City of Albuquerque Stormwater Construction Site Inspection Report

Project Name:	Paseo Nuevo				
Location:	6321 Holly	ESC File No.	C18E038A	NPDES Id. No.	NMR1002WY
Site Contact Name & Agency	Jeremy Zak - Skarsgard	Phone: (o)	505-362-1840		
		Phone: (m)			
Owner	Skip Skarsgard - Paseo Nuevo	Phone: (o)	505-262-2323		
Owner's e-mail		Phone: (m)			
Inspection Date:	08/04/20	Start/End Time:	0730/0800hrs		
CoA Stormwater Inspector:	Timothy E. Sims				
Construction Phase:	earthwork				
Type of Inspection:	<input checked="" type="checkbox"/> Regular	<input type="checkbox"/> Storm Event	<input type="checkbox"/> Post Storm Event >0.25"	<input type="checkbox"/> 311/Complaint	<input type="checkbox"/> Follow Up

RECEIVING WATERS: ONSITE PONDS	
CRITICAL HABITAT: CRITERION "A"; NO CRITICAL HABITATS WITHIN PROJECT AREA	
GPS LOCATION: 35.1761, -106.5760	
PASEO NUEVO PARKING LOT	
PROJECT TITLE	
ALBUQUERQUE, BERNALILLO COUNTY, NM	
CITY, COUNTY, STATE	
04/09/2020	DATE
C. DURKIN	DRAWN BY
INSPECTIONS PLUS

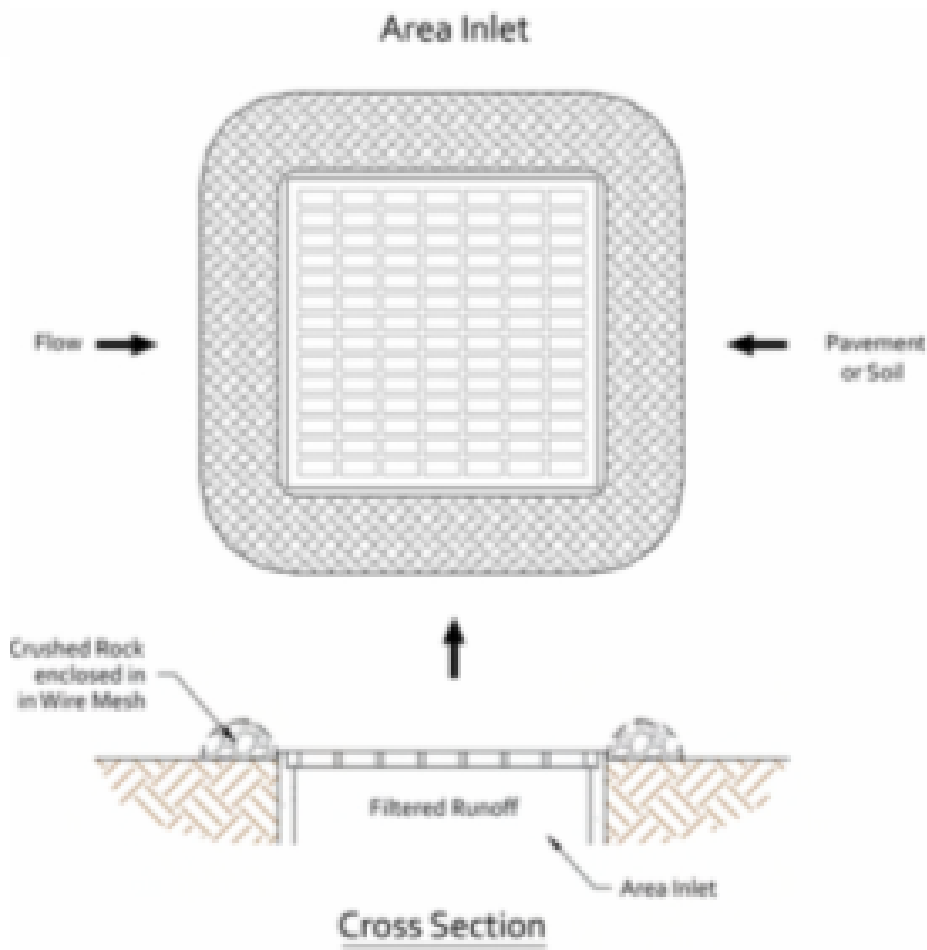
Item Number	Deficiency/ Corrective Action		
1	Submit and acquire SWQ approval. (Install BMP's as outlined in approved plan)		
2	Sediment in access roadway to site requires mitigation.		
3	Cementous washout requires mitigation. Please provide washout location		
4	Please provide sediment BMP on the NW area of the site.		
5	Sediment build up exceeds the allowable 50% of silt fence height. Please mitigate.		
6	Inlet protection required on inlet in Holly approx. 150-180 ft west of site location.		
7	Please provide the all SWPPP self-inspection reports. The initial report and all subsequent reports thereafter to include rain events.		
	***CGI contractor conducting earthwork activities during construction. Site appears to have started during the month of July.		
2.1	Discharge off site? (Y/N)	Yes	: see photo Sediment Street
4	Self Inspection Reports	requested	Latest report Date: Not on File
